From: Laura Gibbons
Sent: 20 February 2019 13:26
To: Planning.Responses
Cc: Anita Gardner
Subject: RE: Planning Consultation on LY/2/19/DOC

Engineers Comments Regarding Condition 3- surface water drainage

APPLICATION NO: LY/2/19/DOC

Description of Works: Approval of details reserved by condition imposed under ref LY/10/17/PL relating to Condition No 3 surface water drainage.

Drawing Title: SITE STORMWATER DRAINAGE PLAN

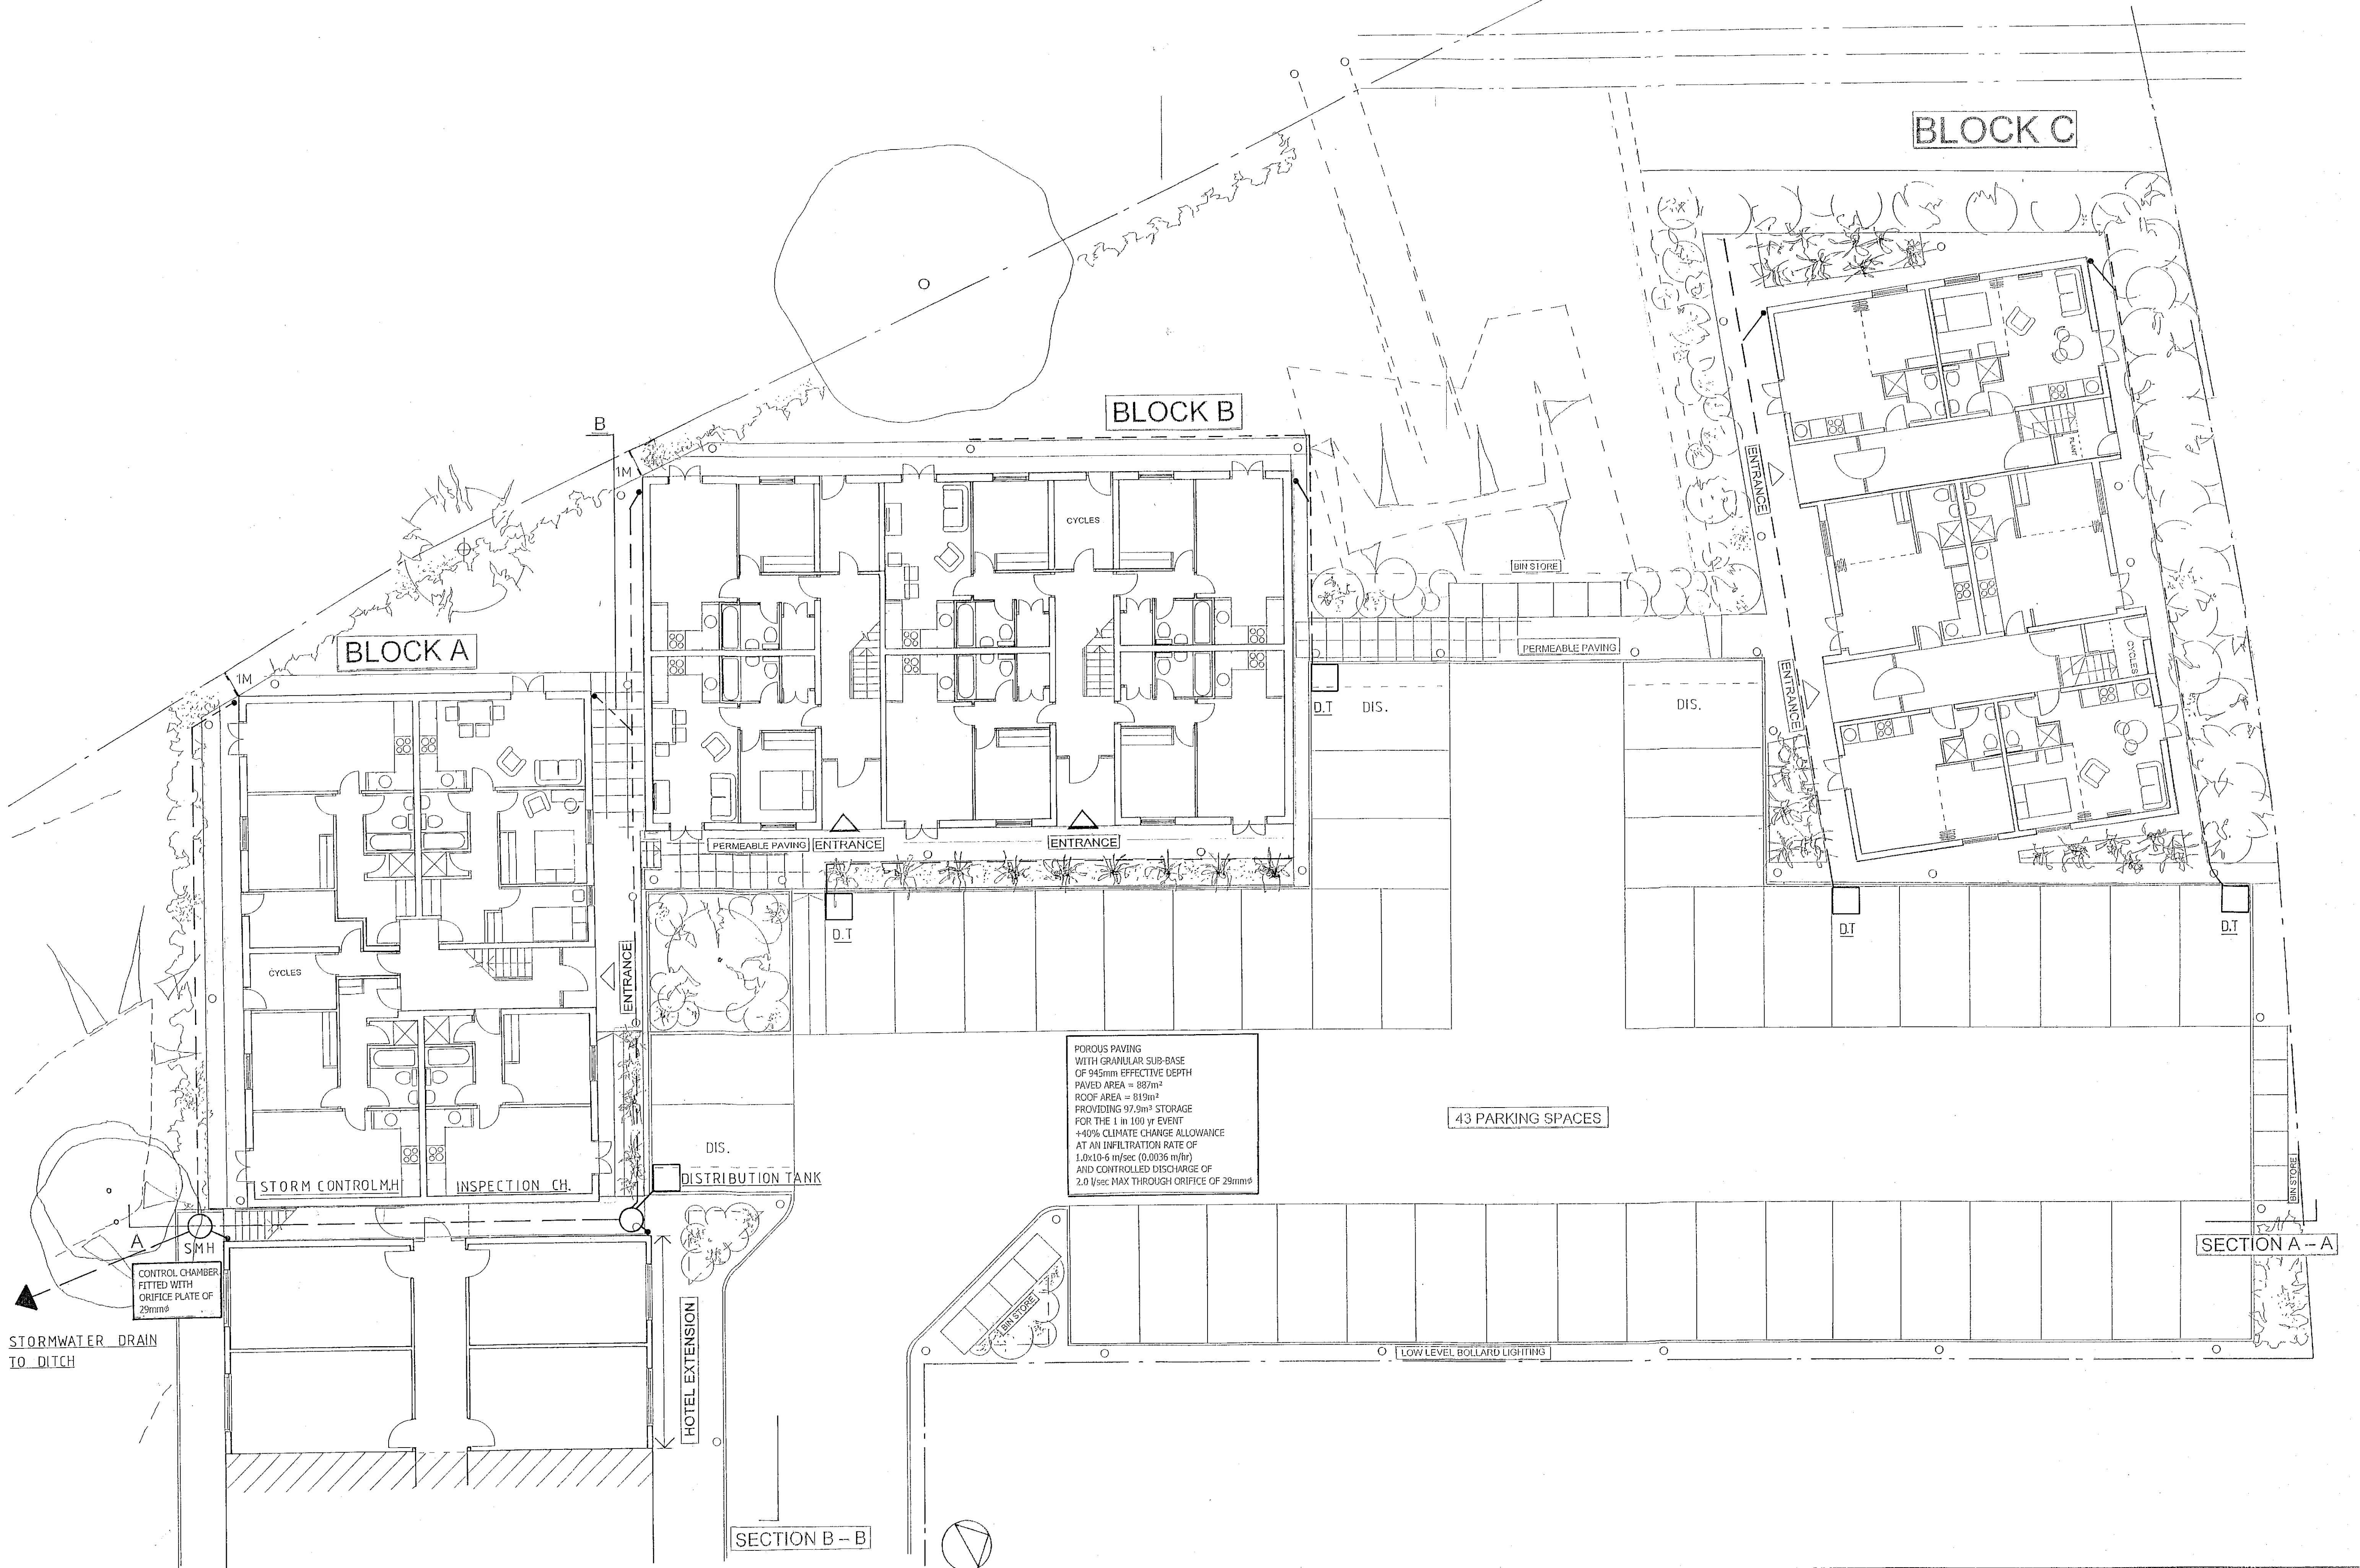
1. Groundwater monitoring was completed March to April, this is insufficient for this scale of development.
We require monitoring October to March inclusive.
2. Proof needs to be supplied to demonstrate that discharge to watercourse is required.
3. Insufficient details on layout plans.
4. No construction details have been supplied.
5. The proposals are to discharge to ordinary watercourse, ordinary watercourse land drainage consent is required. We require evidence to be submitted that demonstrates that this consent is being sought.
